# Rezoning Transportation Analysis

Petition Number: 2023-044

**From: Jake Carpenter, PE**  
Jacob.carpenter@charlottenc.gov  
980-221-5675

Revision Log:	Date	Description
	07-26-23	First Review (TM)
	08-23-23	Second Review (ME)
	09-28-23	Trip Generation Update (DR)

JOB # 23007 DATE: 01/30/23 SCALE: 1" = 150' DRAWN BY: JAC APPROVED BY: LWL

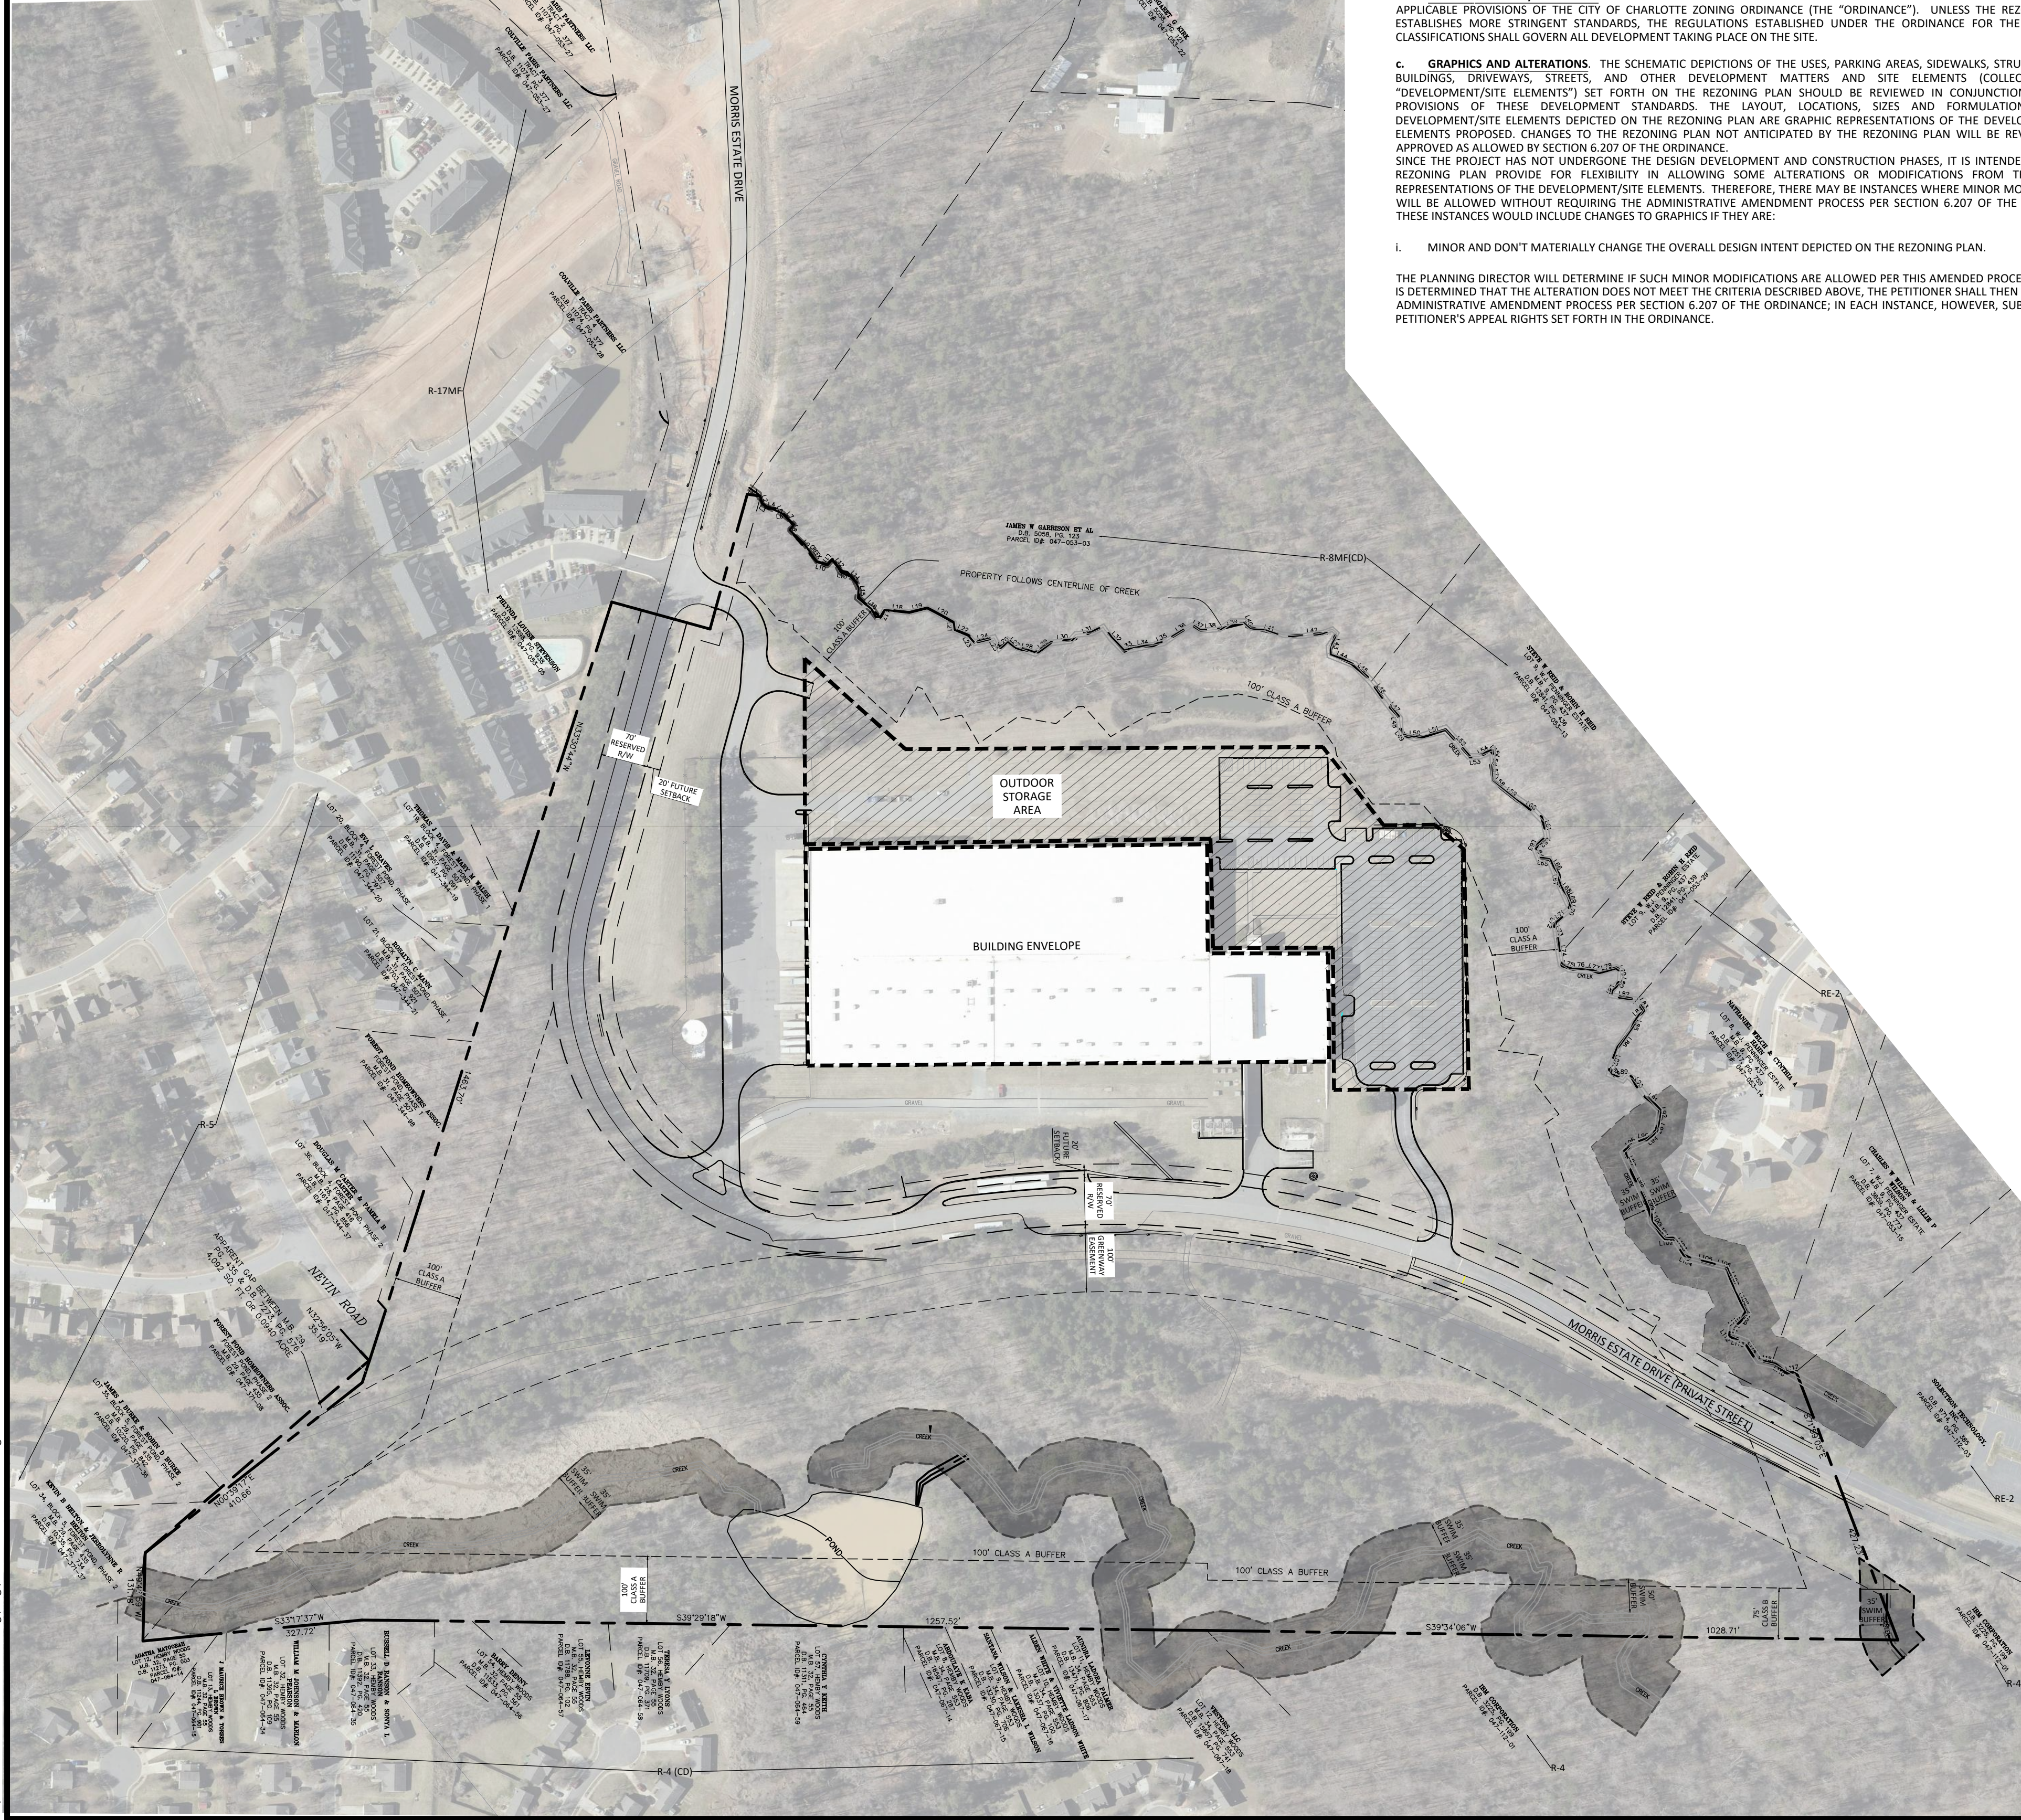
- a. ~~**Morris Estates Drive:** Location of curb and gutter to be moved to 24 feet from roadway centerline to accommodate the Charlotte Streets Map with a roadway typical section of 2+ Avenue with Bike Lanes.~~

**3. ~~Revise site plan and conditional note(s) to commit to reserving 80 feet of right-of-way from the road centerline along Morris Estates Drive. The site plan shall label and dimension the right-of-way from the road centerline.~~**
